**AeroSuperBatics  
Rendcomb Airfield  
White Way  
Cirencester  
Gloucestershire  
GL7 7DF**

*ADDITIONAL INFORMATION*

Acoustics Report 2122/R03  
2<sup>nd</sup> August 2023

Figure 3. Friday & Saturday 23-24/9/22 survey data survey

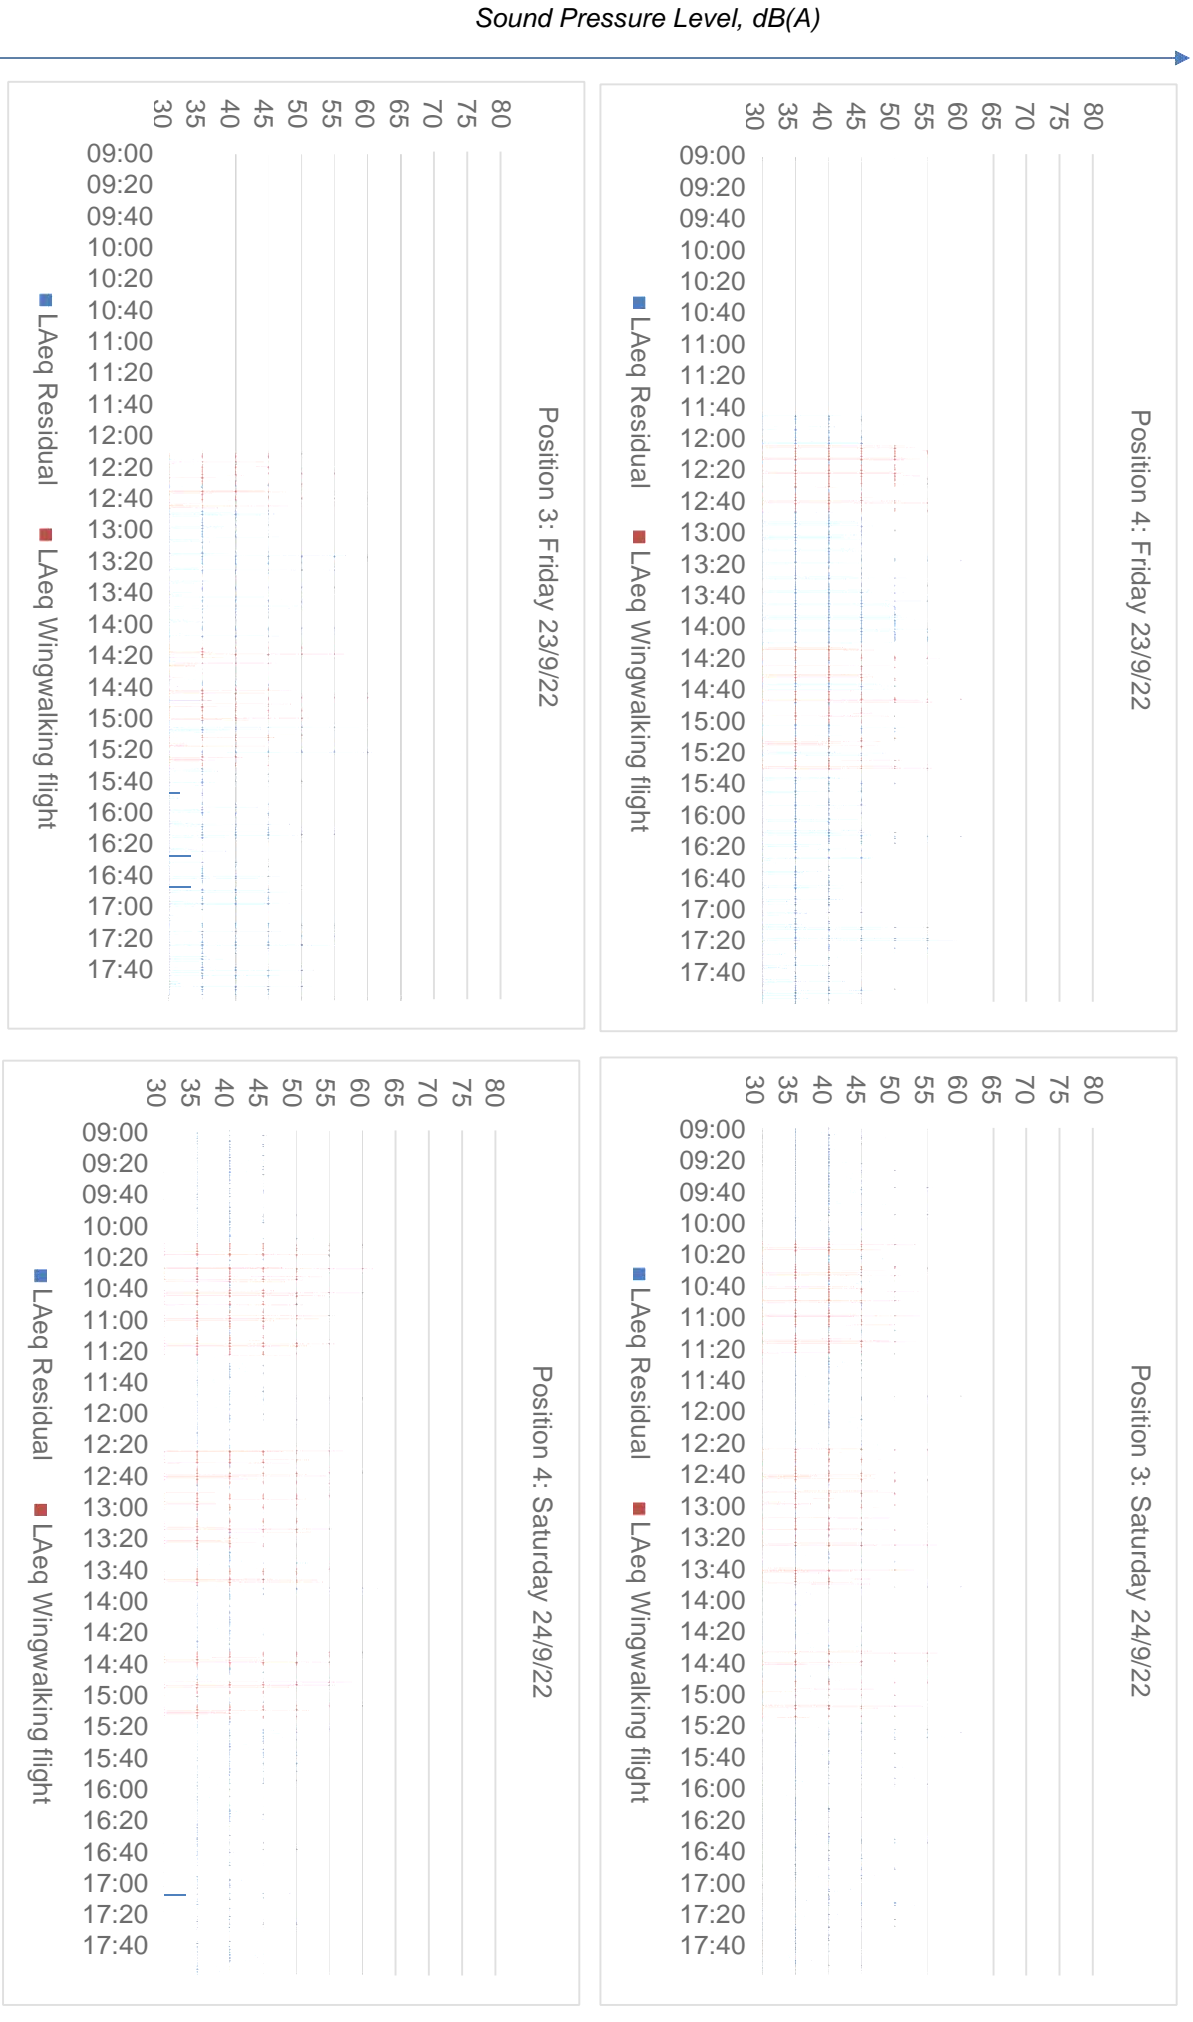
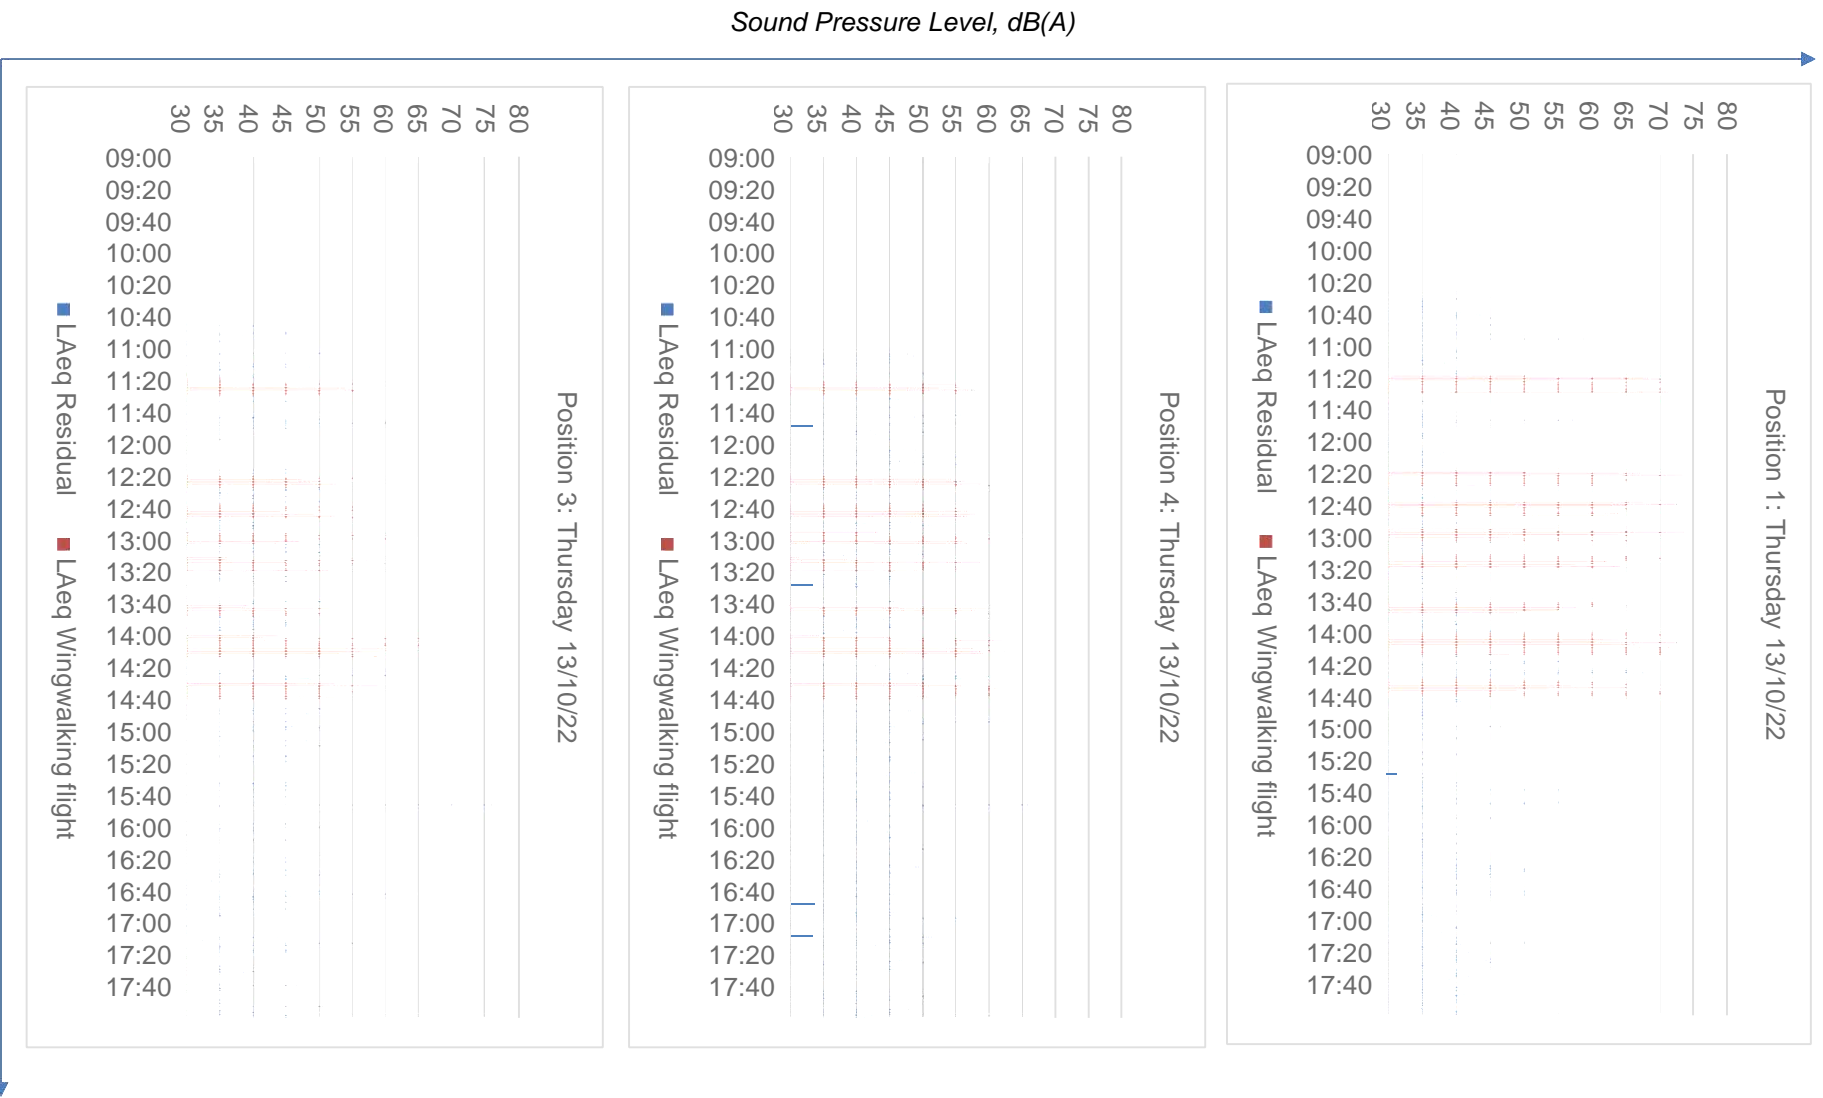
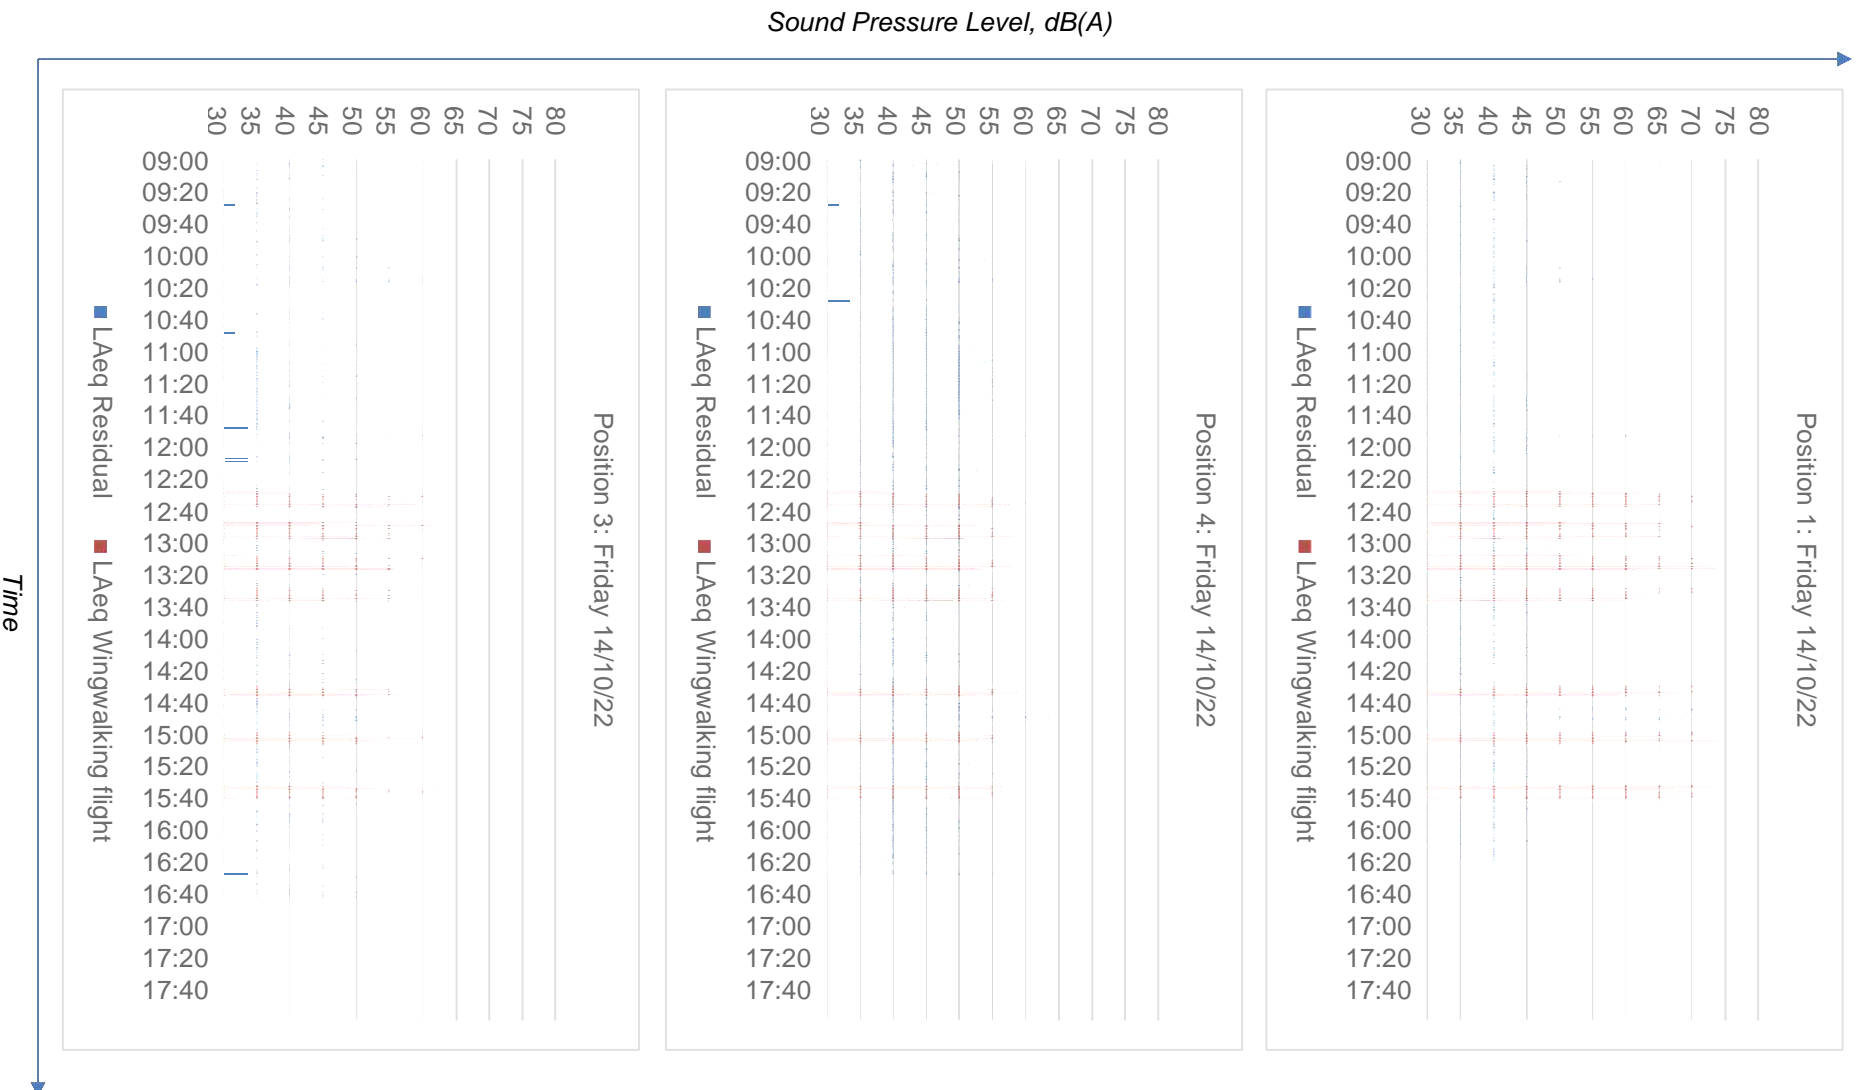
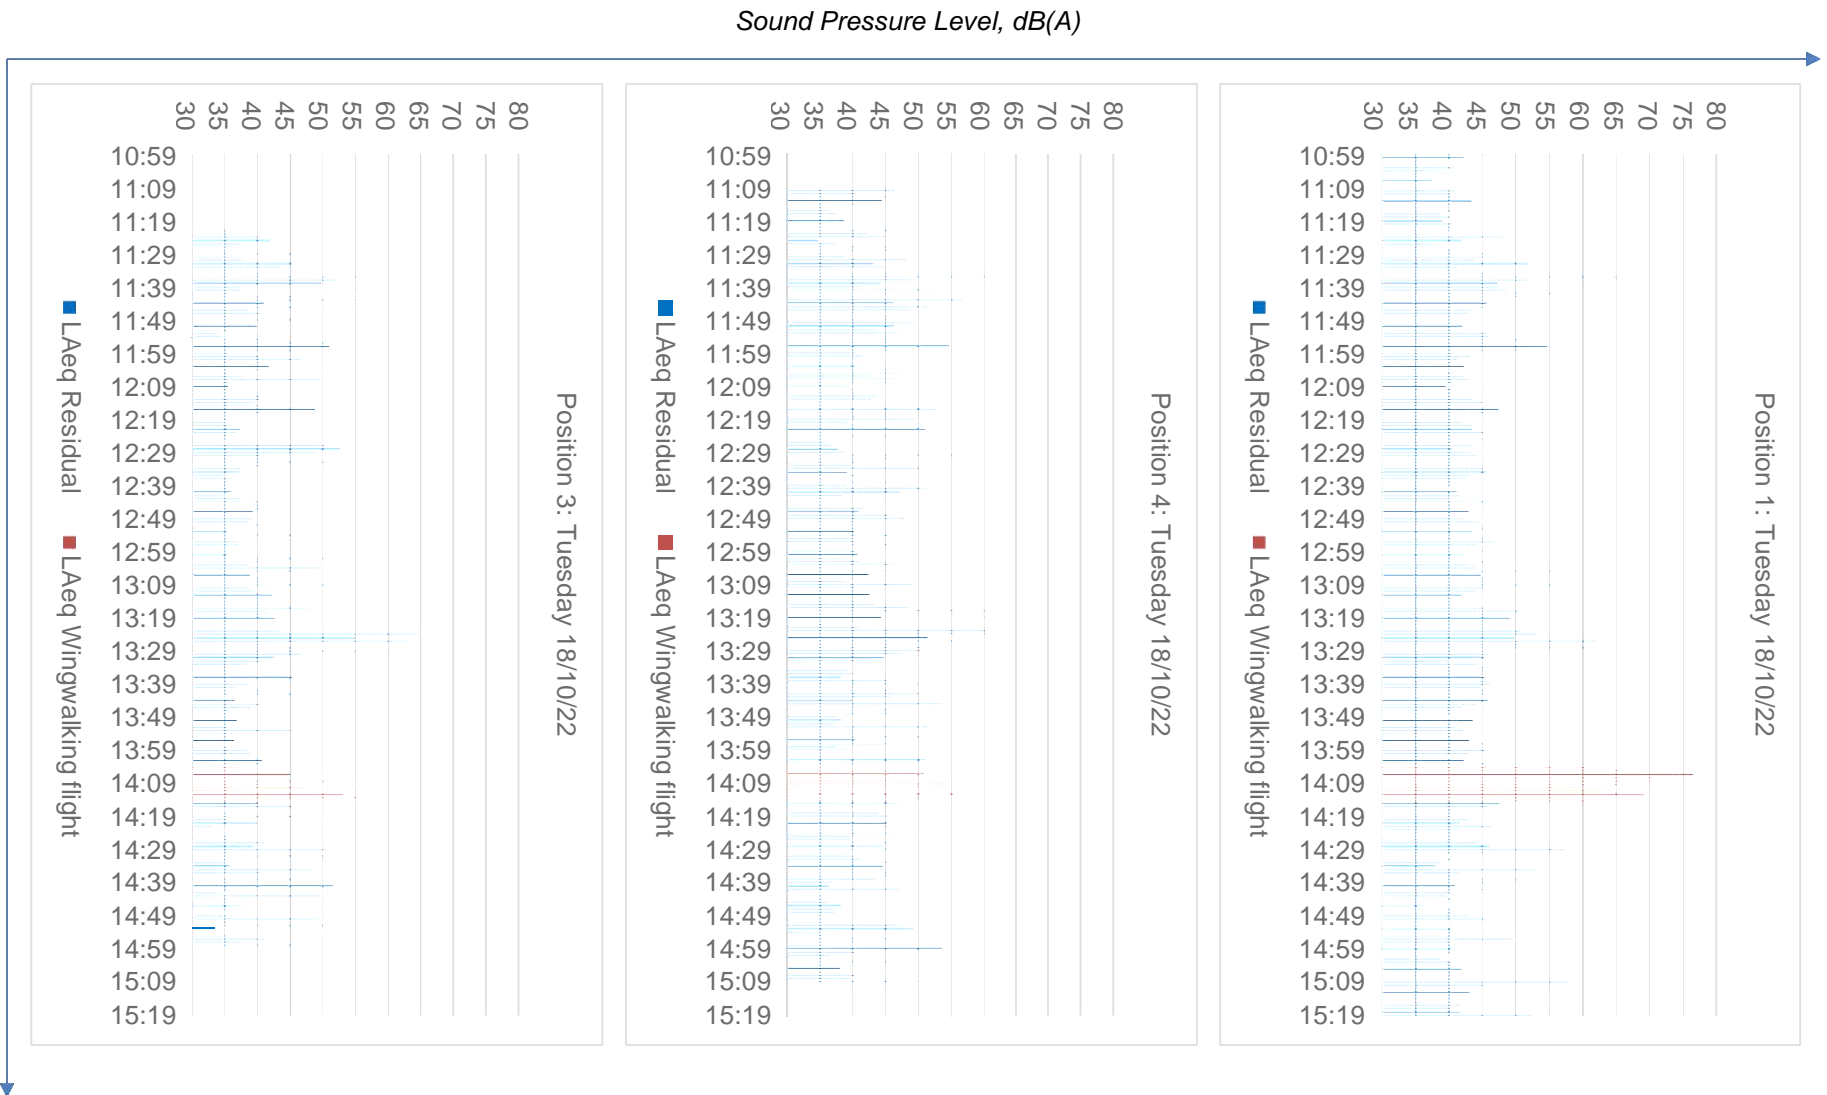
**SEC:** Clarification on how observation/analysis has been used to define periods with and without flight in the unattended graphs. From review of unattended graphs it would appear to show high noise levels which have not been attributed to wingwalking flanking the periods with wingwalking. Did Rendcomb Airfield provide engine on/off times or flight logs to define the flight times? And has consideration been given to remove potentially anomalous events?

**SEC:** Please kindly provide the tabulated 1-minute data used to produce the unattended graphs

**Matrix:** AeroSuperBatics provided the number of flights on each surveyed day, and additionally the approximate flight times on the 23 & 24/9/22.

During periods that the surveys were attended, the start and end times of the flights were recorded, which included taxiing and engine on times. For periods that the monitors were unattended, the survey data was analysed to identify sections of corresponding elevated noise levels at Positions 1, 3 and 4; the elevated values recorded at Position 1 informed on the total duration of the flight.

The number of identified flights (observed and determined from analysis of the noise data) matched the number of flights provided by AeroSuperBatics.

The noise levels recorded at Positions 1, 3 and 4 during the wingwalking flights will have also included the contribution of non-wingwalking noise sources; due to the irregular occurrence of these noise events it is not

possible to remove the contribution of these other noise events from the survey data.

The elevated noise levels recorded outside of the flight periods will have been due to various other noise sources such as passing vehicles or non-wingwalking over-flights.

**Matrix:** Tables 1 – 6 provide the consecutive 1-minute noise data obtained at measurement Positions 1, 3 and 4. The periods of identified wingwalking flights (either from observation or analysis of the noise data) are presented in red.
